STATE OF NORTH CAROLINA
DEPARTMENT OF TRANSPORTATION

November 10, 2014

Subject: **Request for Modification to Individual Section 404 Permit and to Individual Section 401 Certification for Section R-2519A**
US 19/US 19E Improvements from SR 1336 (Jacks Creek Road) to SR 1186 (US 19) west of Micaville Yancey County NCDOT Division 13
State Project Numbers 6.869005T and 6.909001T
T.I.P. Project Number R-2519A
Debit \$570.00 from WBS Element 35609.1.1

PROJECT REFERENCE NO. R-2519A		SHEET NO. 20	
R/W SHEET NO.			
ROADWAY DESIGN ENGINEER		HYDRAULICS ENGINEER	
PRELIMINARY PLANS			
CONST. REV.			
R/W REV.

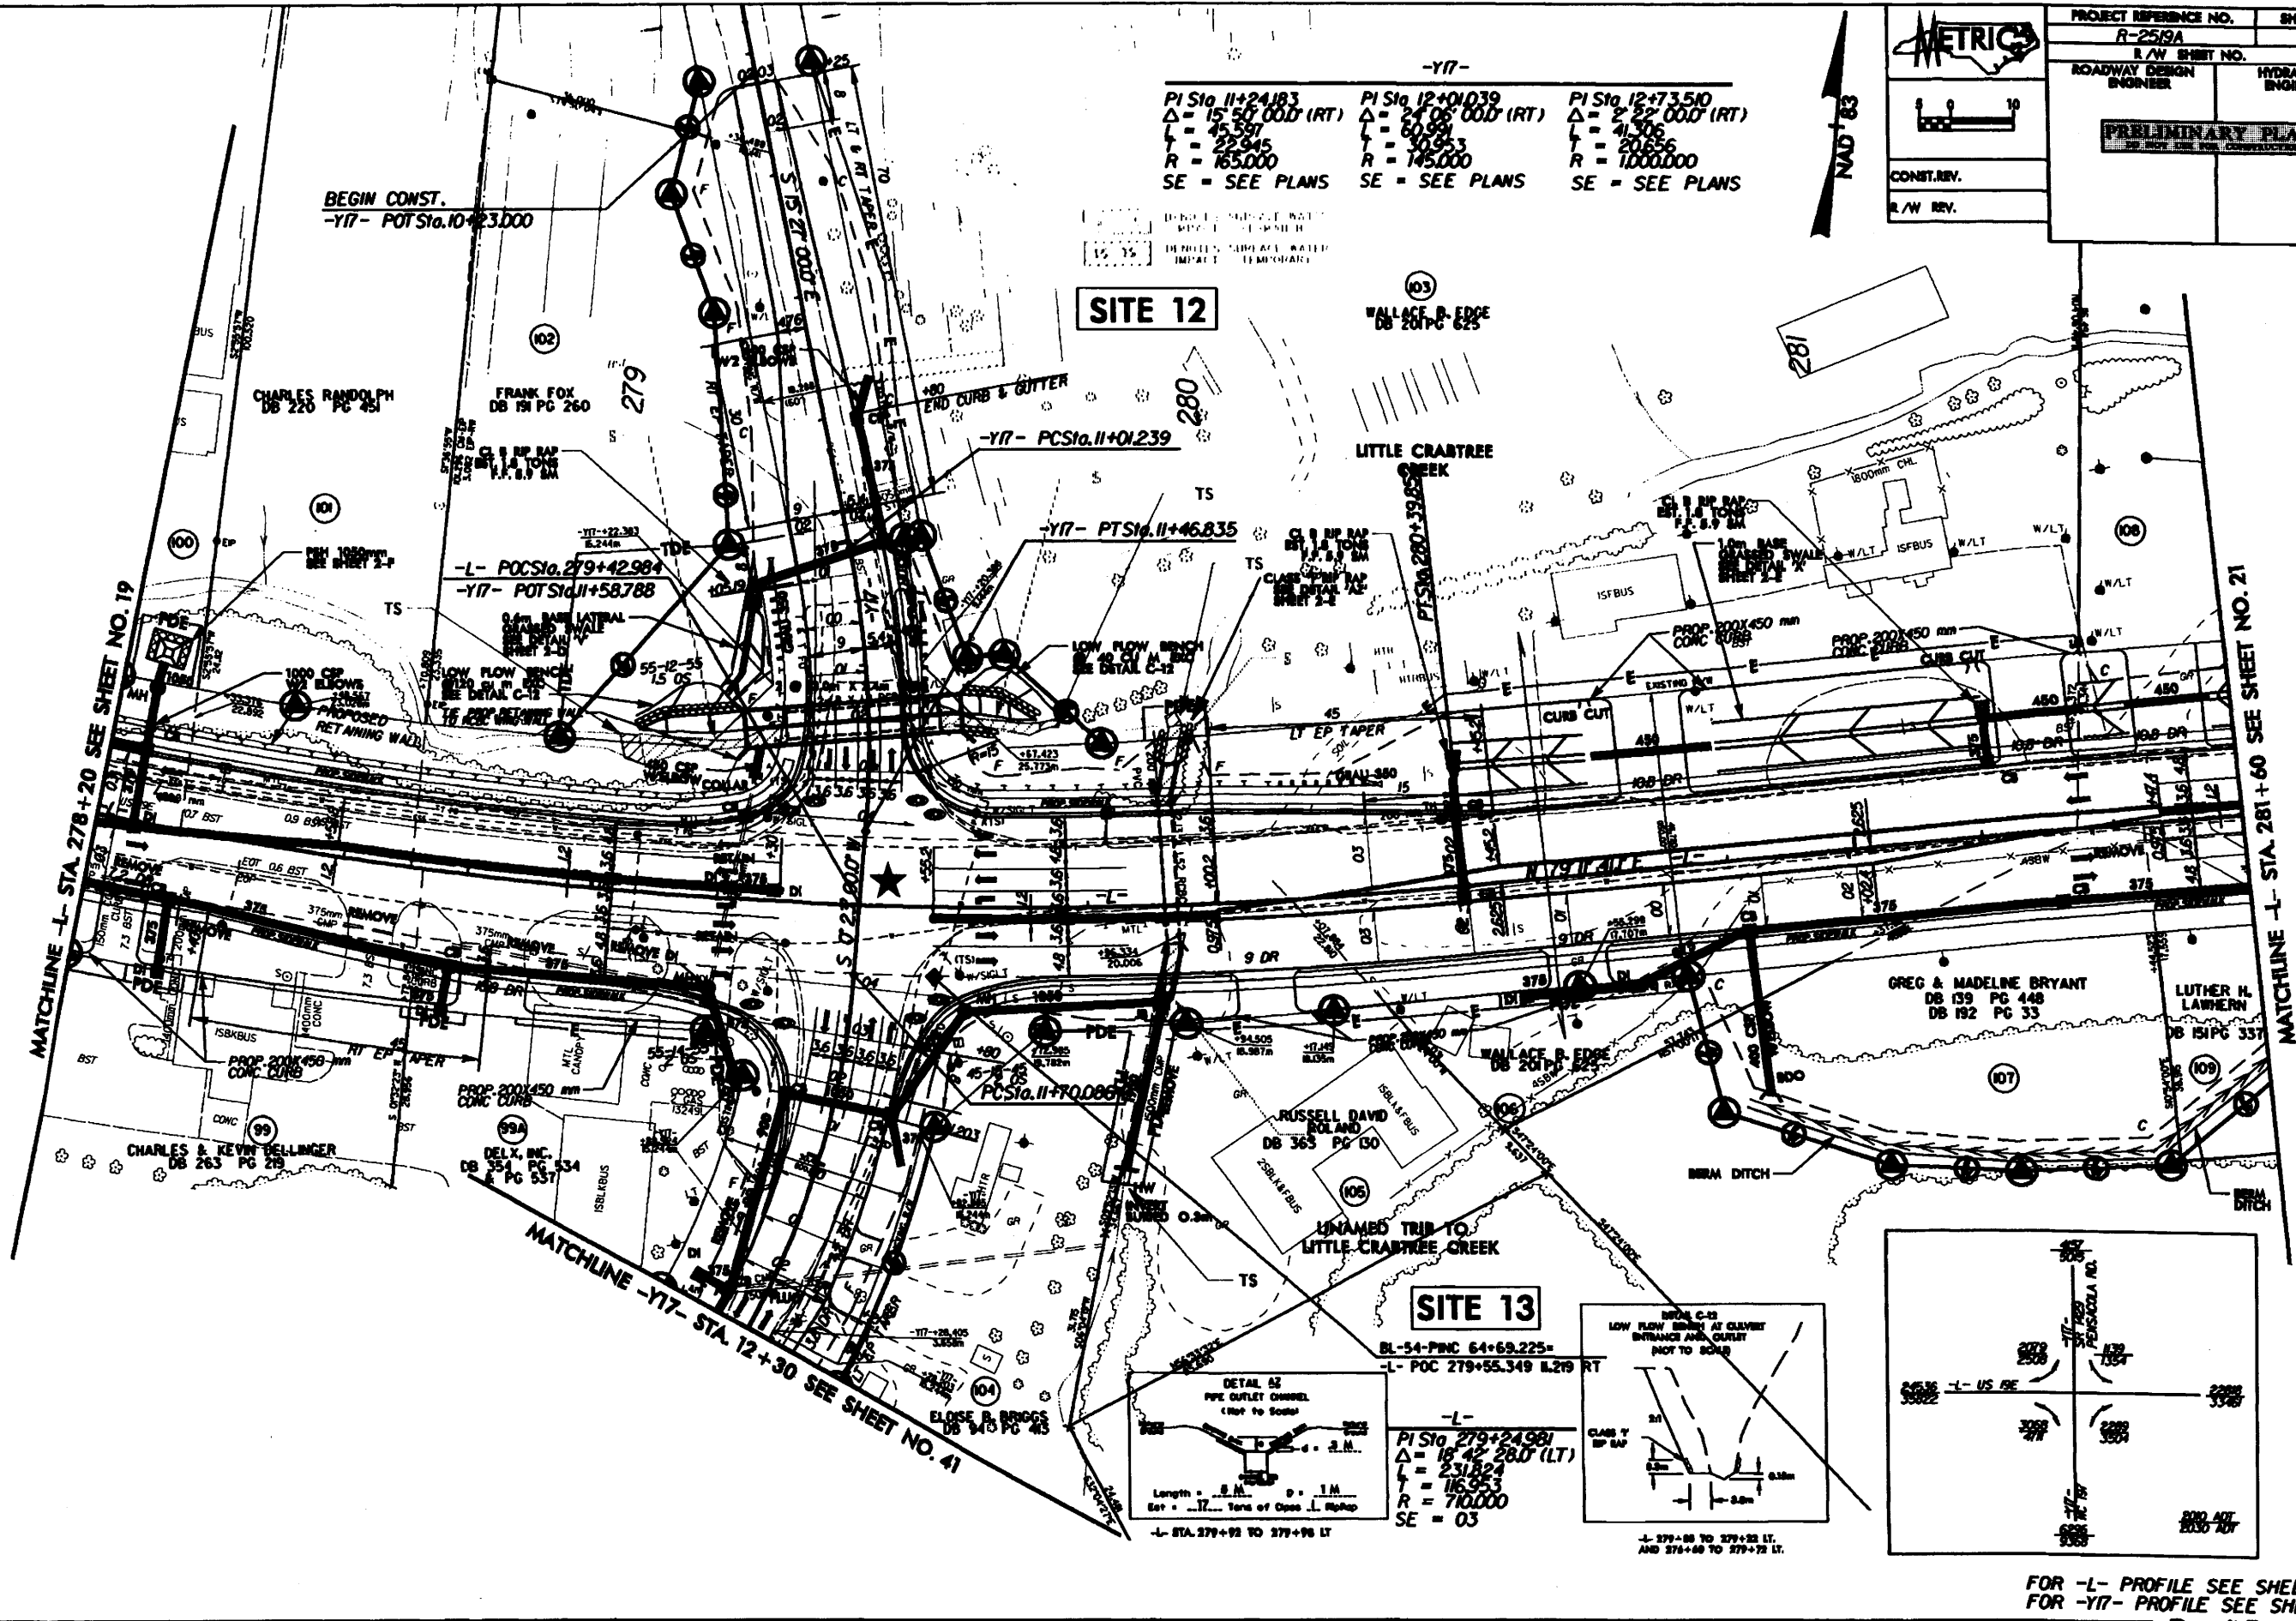
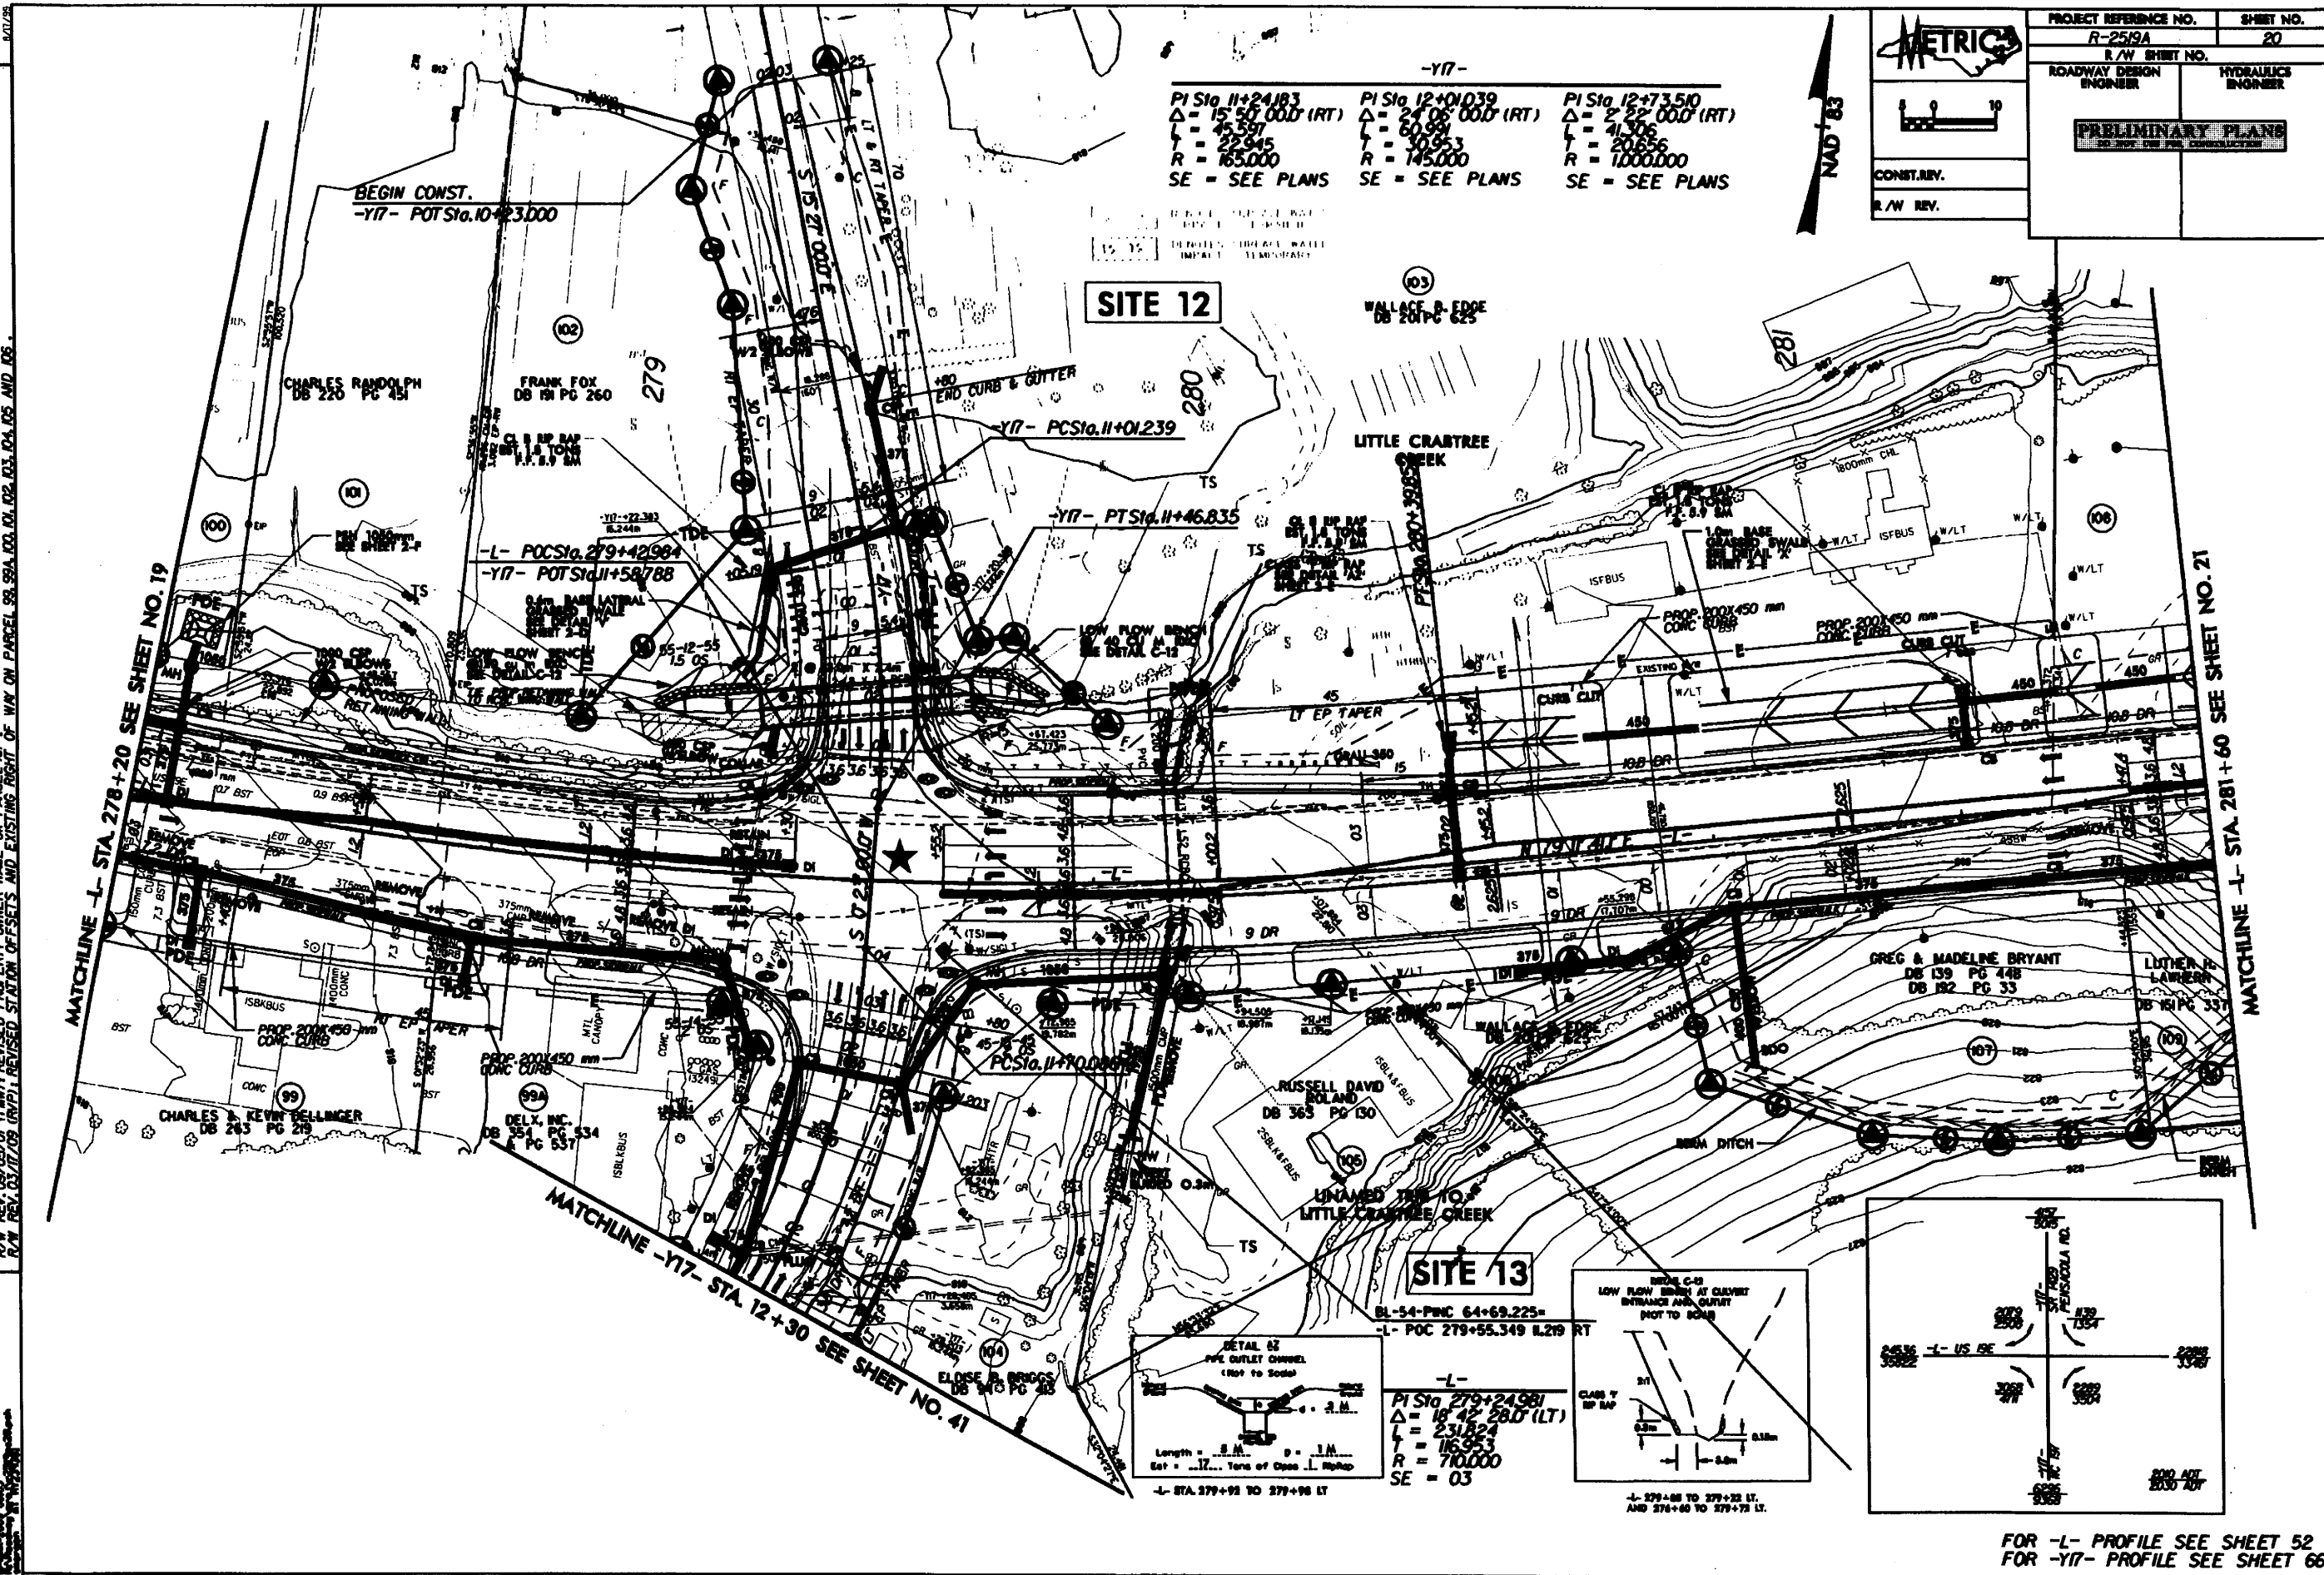
This letter addresses modifications to Section R-2519A of the US 19E widening project that extends from SR 1336 (Jack's Creek Road) to SR 1186 (US 19) west of Micaville. The North Carolina Department of Transportation (NCDOT) requests approval for revisions to the Individual 404 Phased Modification issued January 1, 2010 and the Individual 401 Phased Modification issued September 4, 2009. NCDOT proposes to eliminate a proposed retaining wall depicted on Permit Drawings page 37 and 38 (Permit Site 12) and Roadway Plan Sheet 20.

Permit Site 12 is located near the intersection of Pensacola Road (NC 197) and US 19 E where Little Crabtree Creek passes through an existing double barrel culvert. The discovery of a bedrock layer along Little Crabtree Creek has prevented the installation of the proposed retaining wall. As a result, NCDOT proposes a 2:1 fill slope at this location which will encroach upon Little Crabtree Creek necessitating the realignment of the stream and the extension of the culvert under Pensacola Road.

The revised permanent impacts at Site 12 are **305 linear feet**, an increase of 173 linear feet over the original estimated impacts of 132 lf (34 lf culvert extension/98 lf of bank stabilization).
